HANNAH RIDGE AT FEATHERGRASS FILING NO. 5

CONSTRUCTION PLANS

SF-18-038

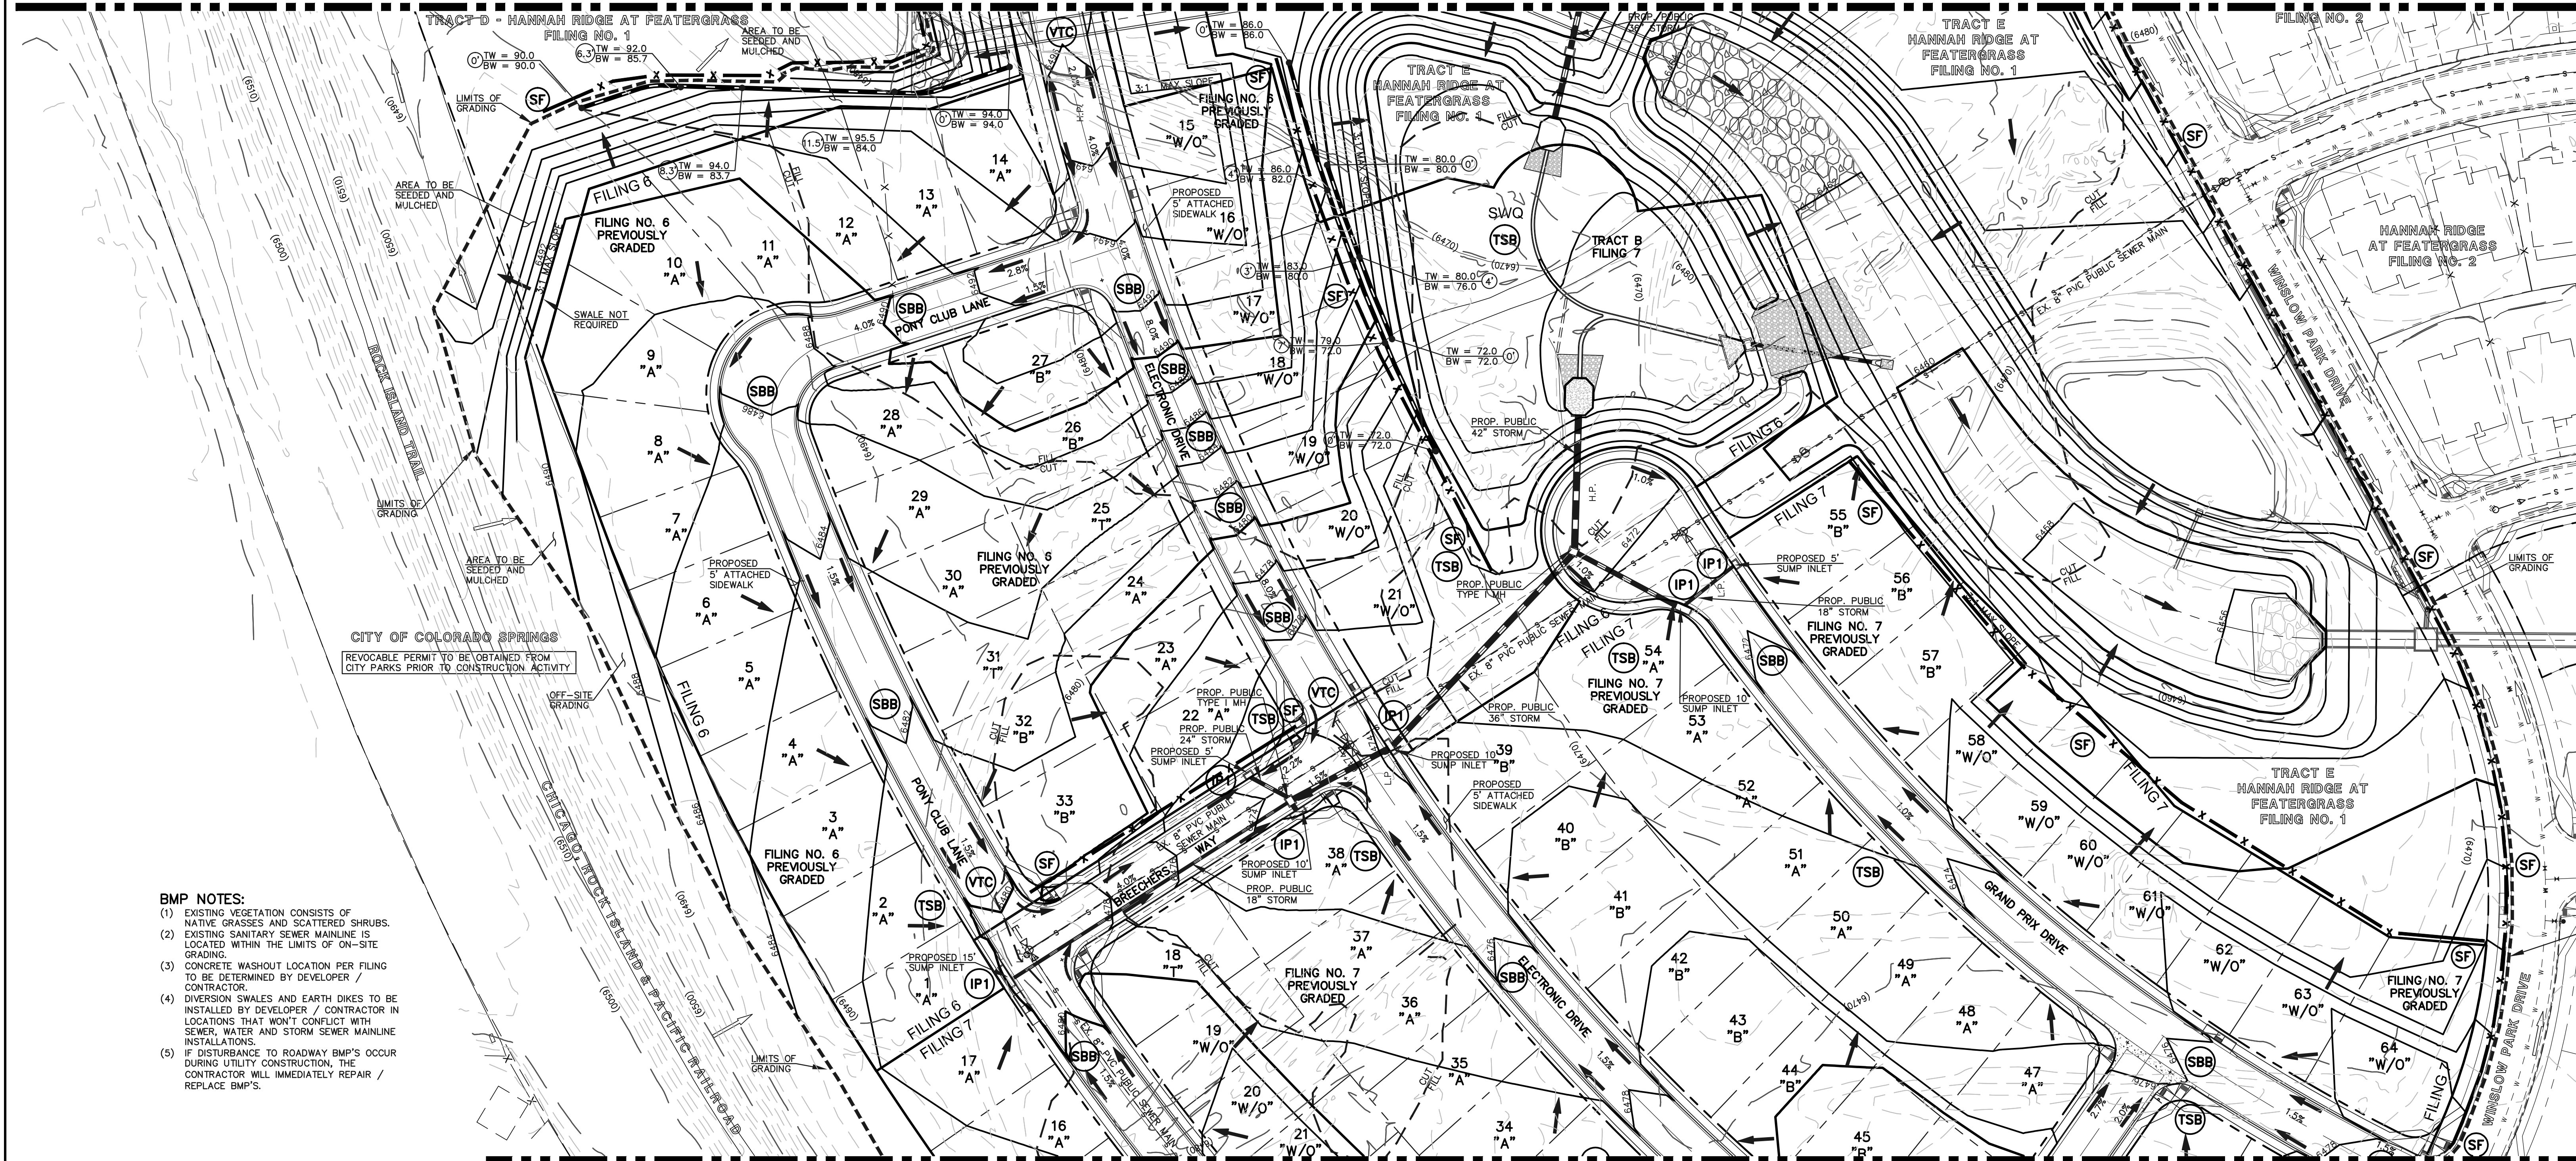
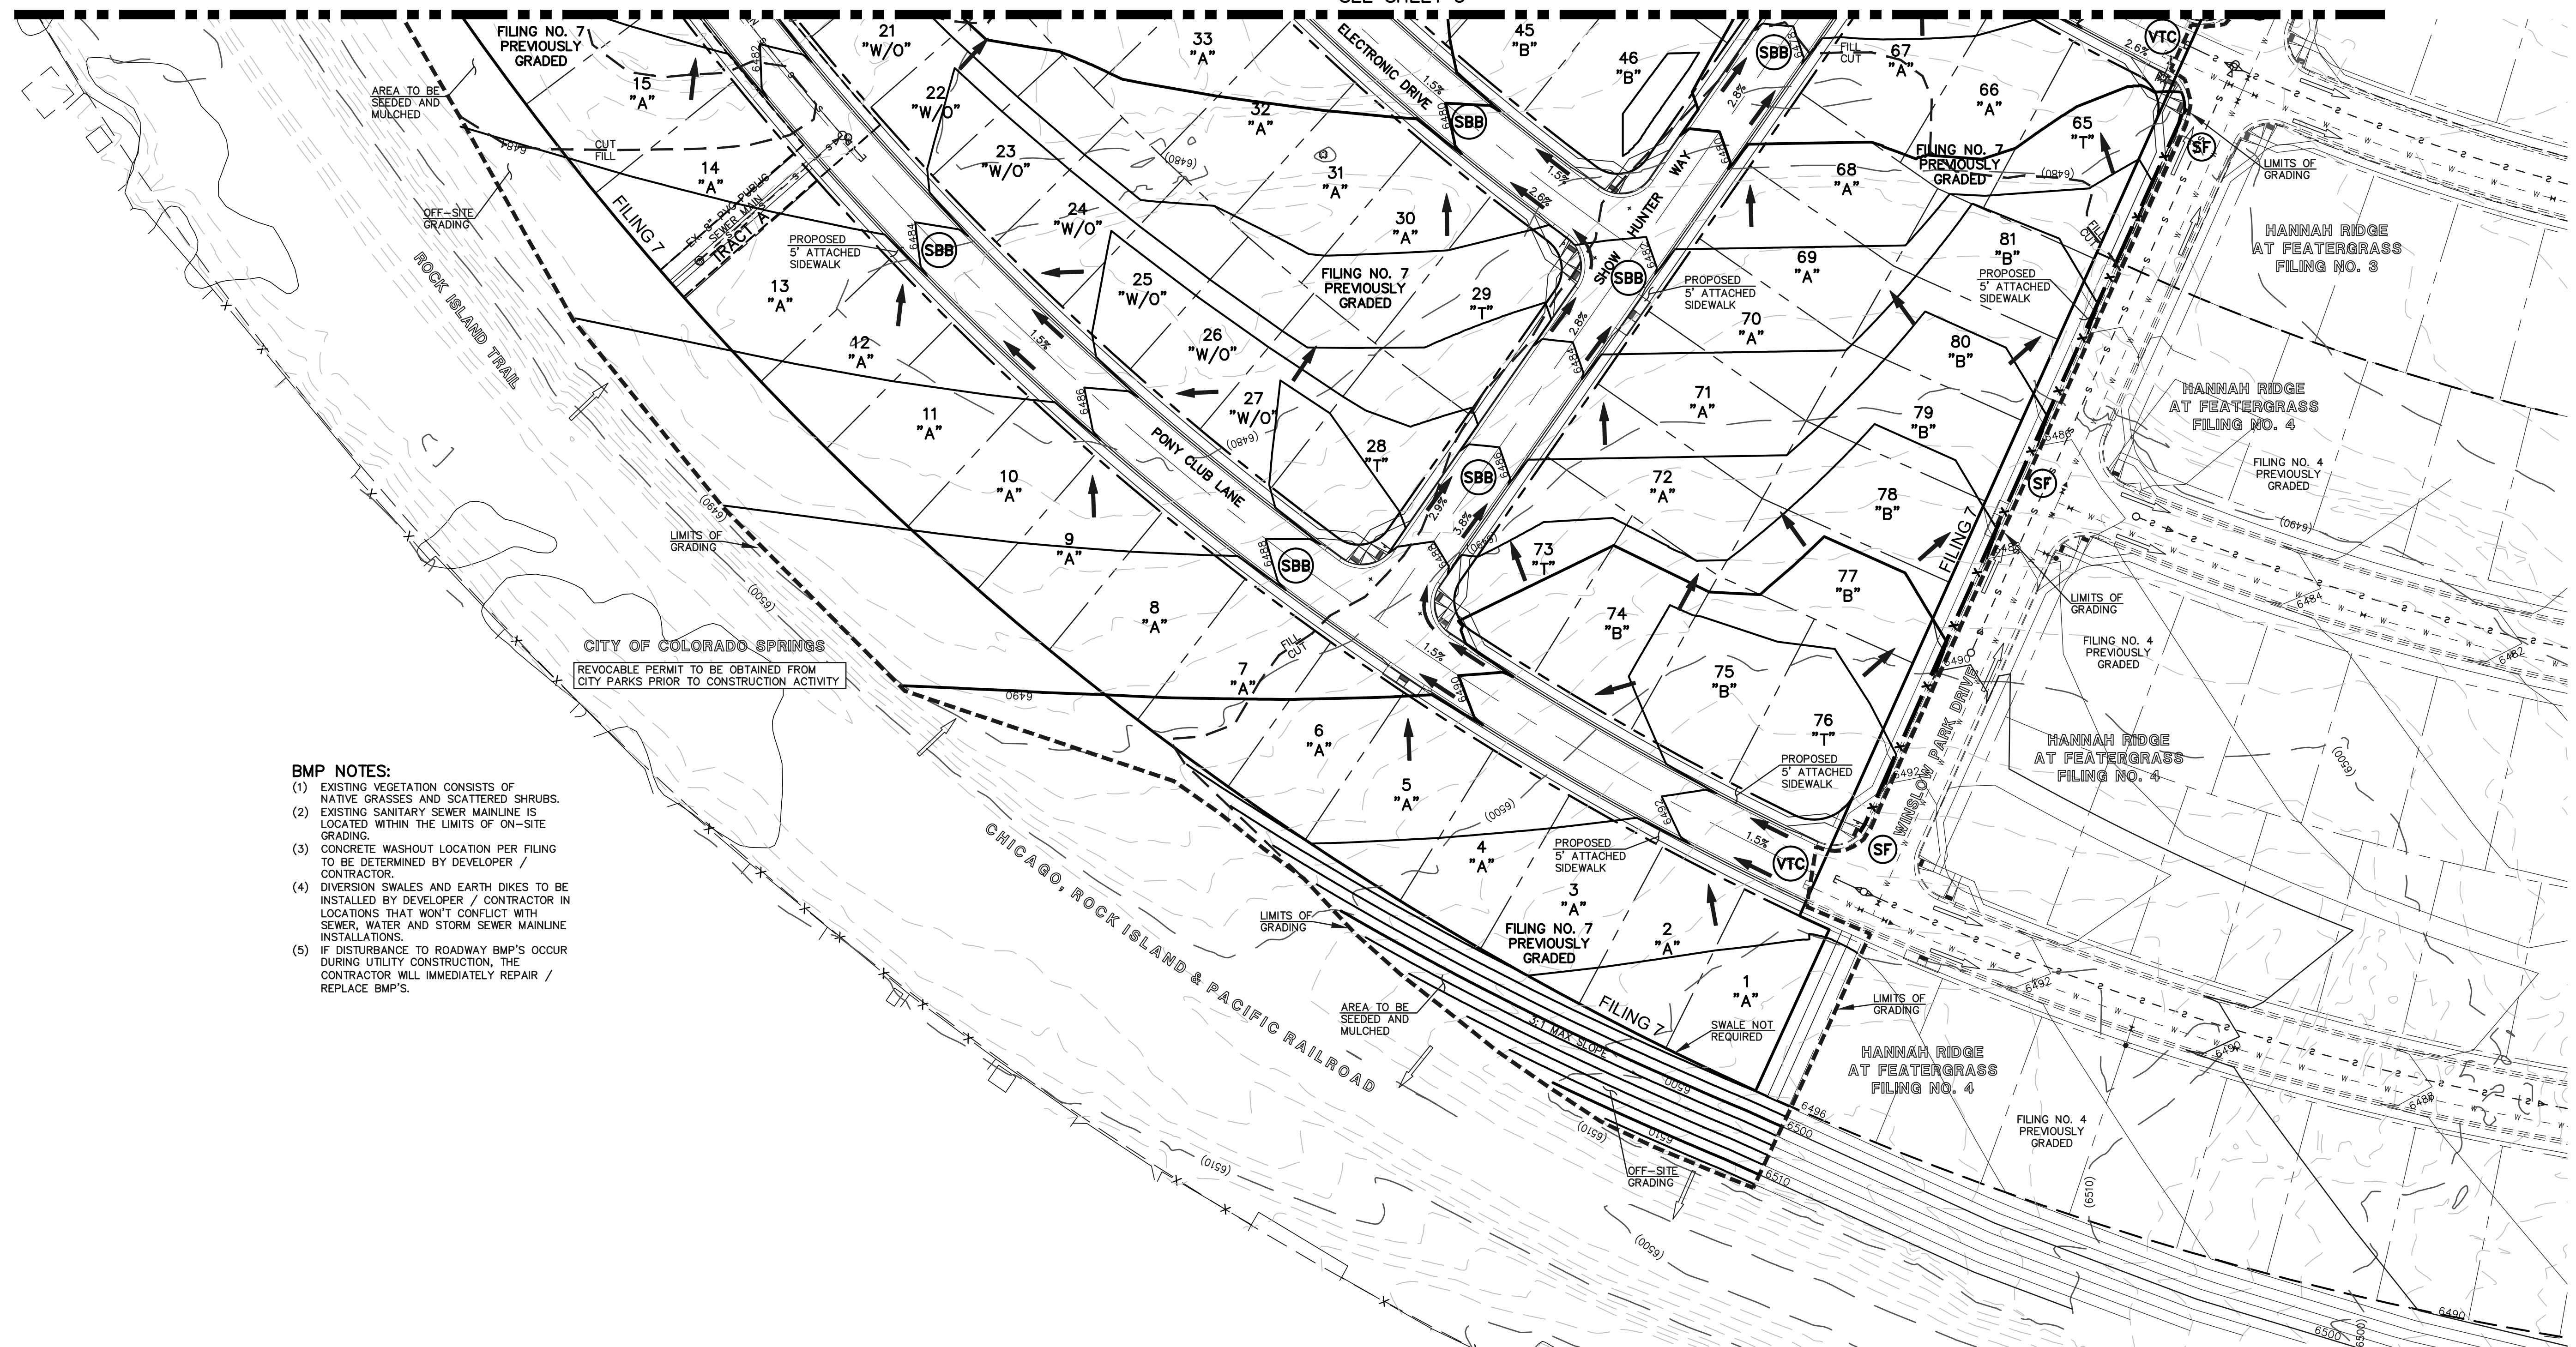
Final grading contours are on top of the box culvert end section and rip rap. This implies that they are buried. Please correct this.
